ADC ref: P/92/11/DOC

Butterlees Barn, Butterlees Farm, LAGNESS
Application P/145/08 – Discharge of Conditions

BUTTERLEES BARN - LHAGNESS
SITE PLAN AS PROPOSED
DWG: BUT/D-01F 1:200 @ A3 JUL 2008
MALCOLM SIMMONDS ARCHITECTS

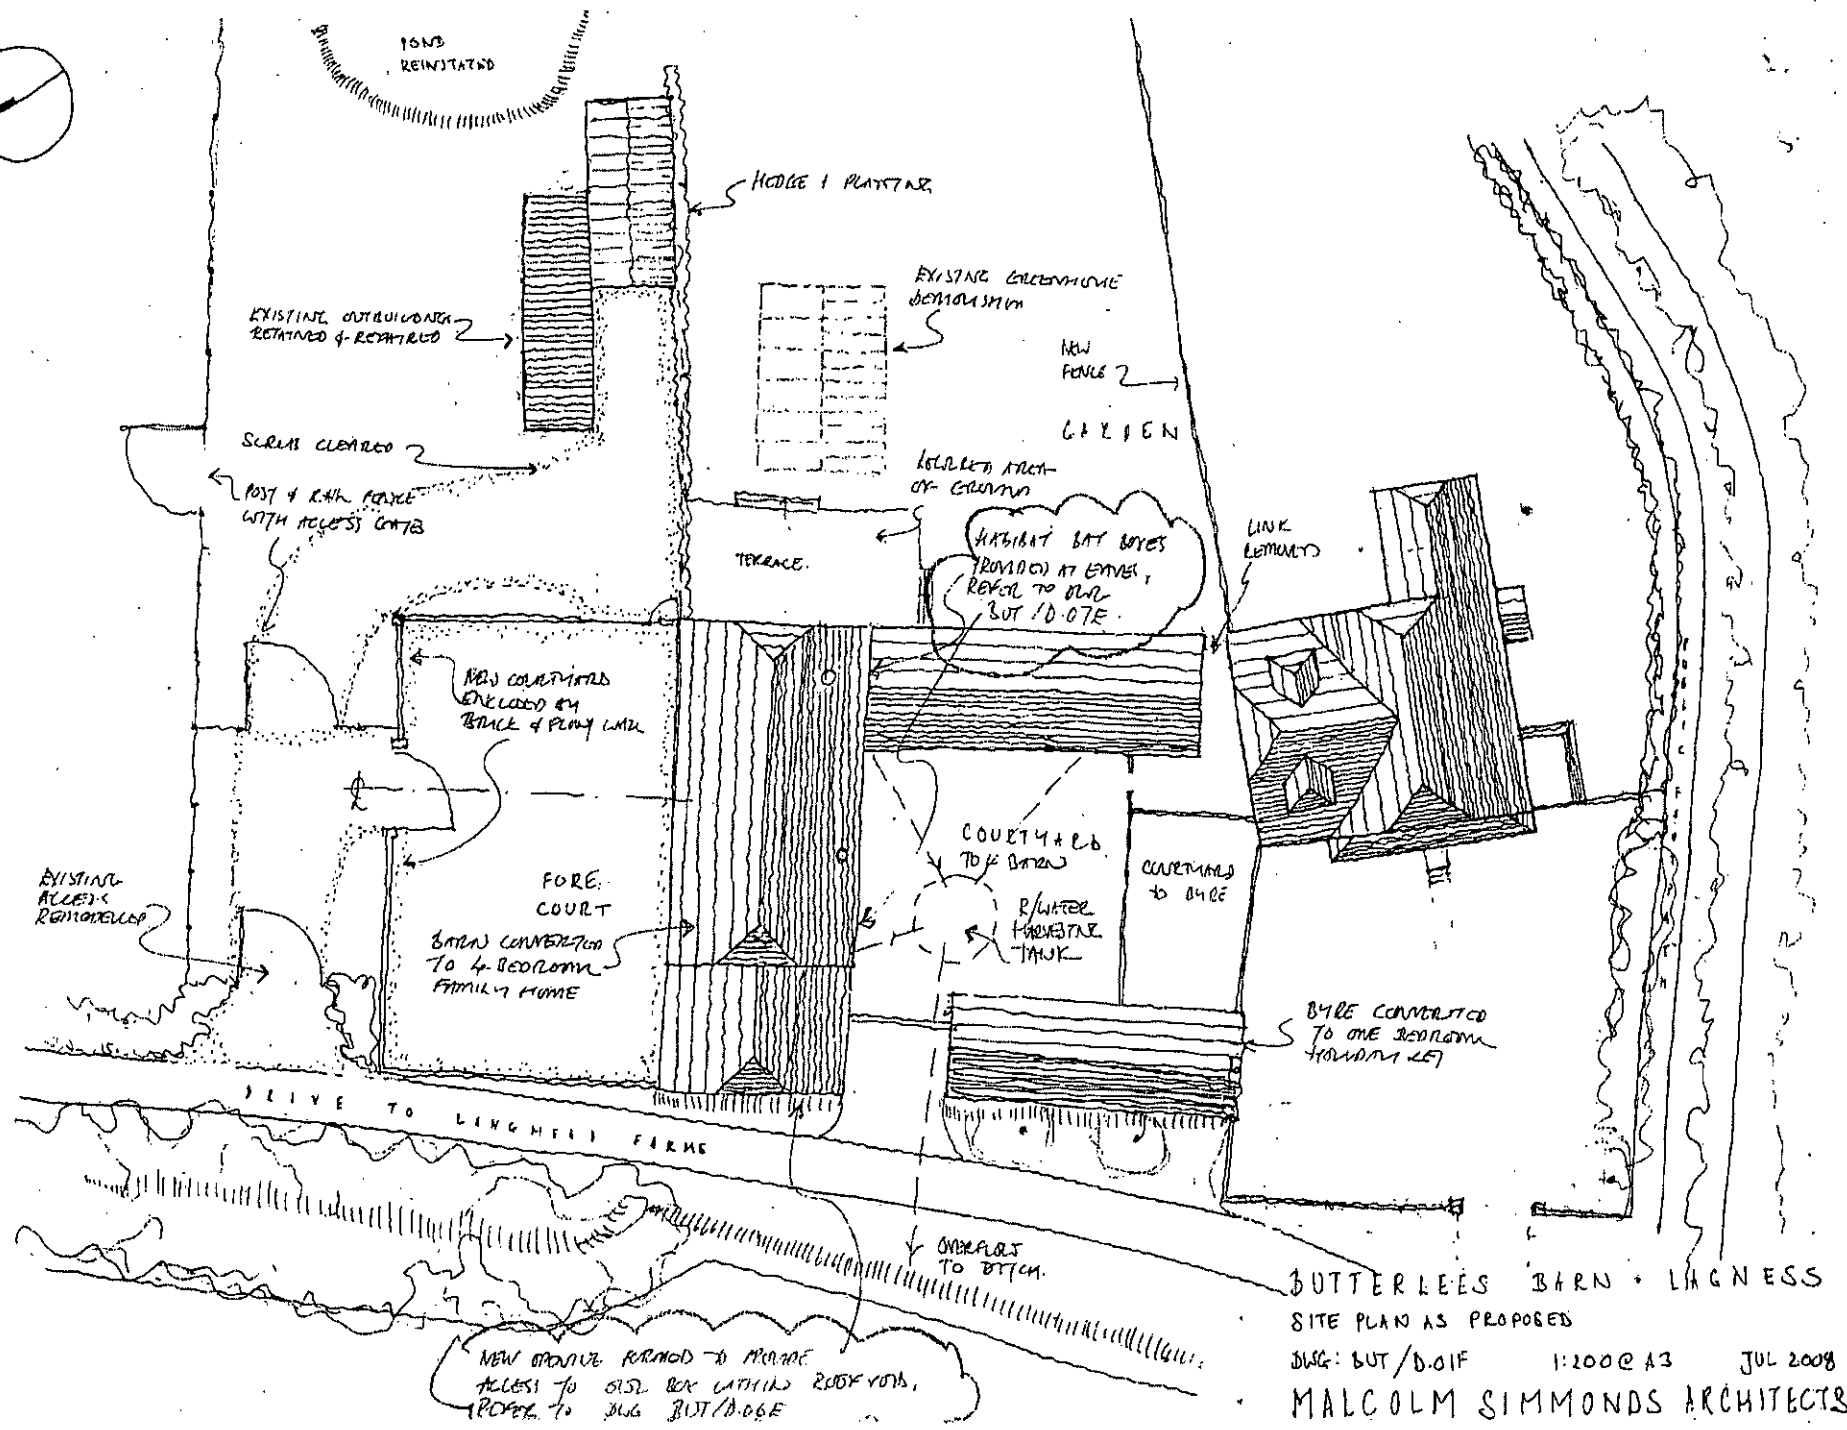
Thanks for the additional information. The locations for the bat boxes and the owl box seem appropriate. One would normally expect greater detail in terms of the design of the owl loft rather than simply a proposal to install an owl box in the roof void. Figs. 2 & 3 in attached Natural England guidance show how an owl loft can be created. If the applicant can commit to a similar design, I would then discharge the condition.

BUTTERLEES BARN - LAGNESS
BARN & BYRE ELEVATIONS AS PROPOSED
LWG/BUT/D.OGE 1:100 C.A.B. JU 008
MALCOLM SIMMONDS ARCHITECTS

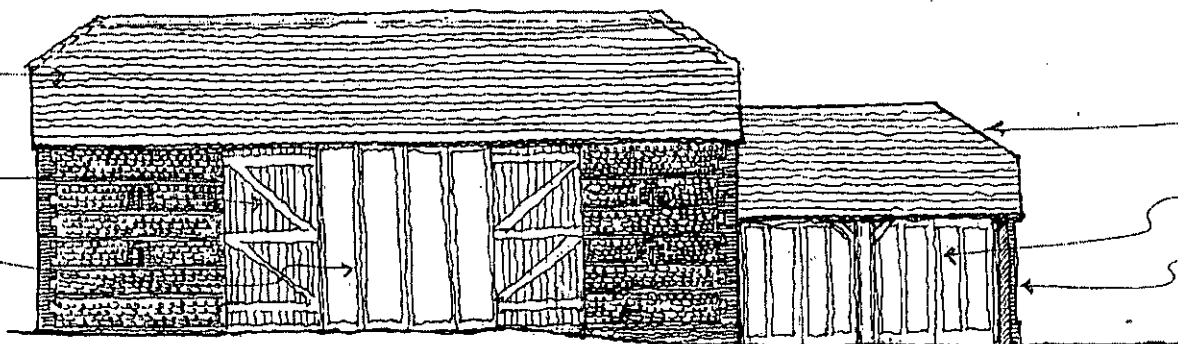
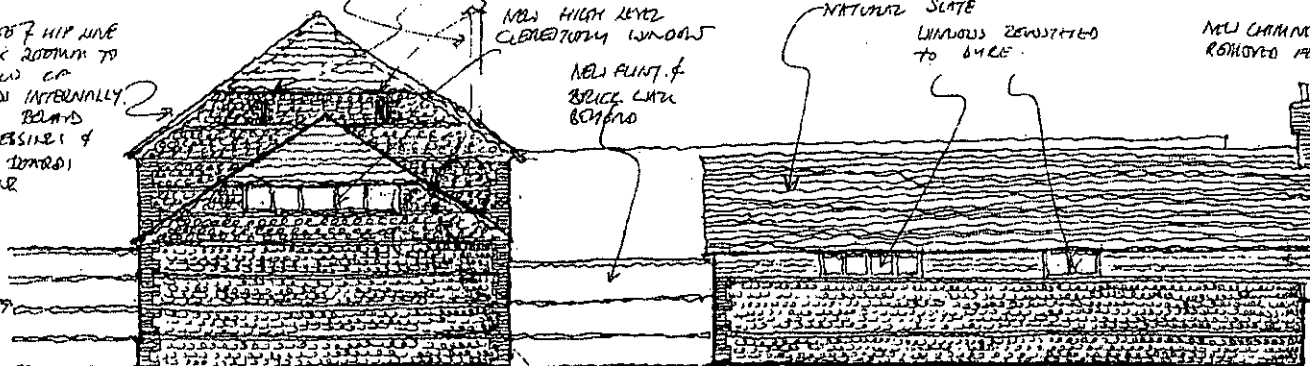
I note that Don, in his comments of 6th Feb 2012, recommended access and nesting provision (e.g. Schwegler No. 10 nestbox) should be provided for Swallows. Maybe this wasn't conditioned.
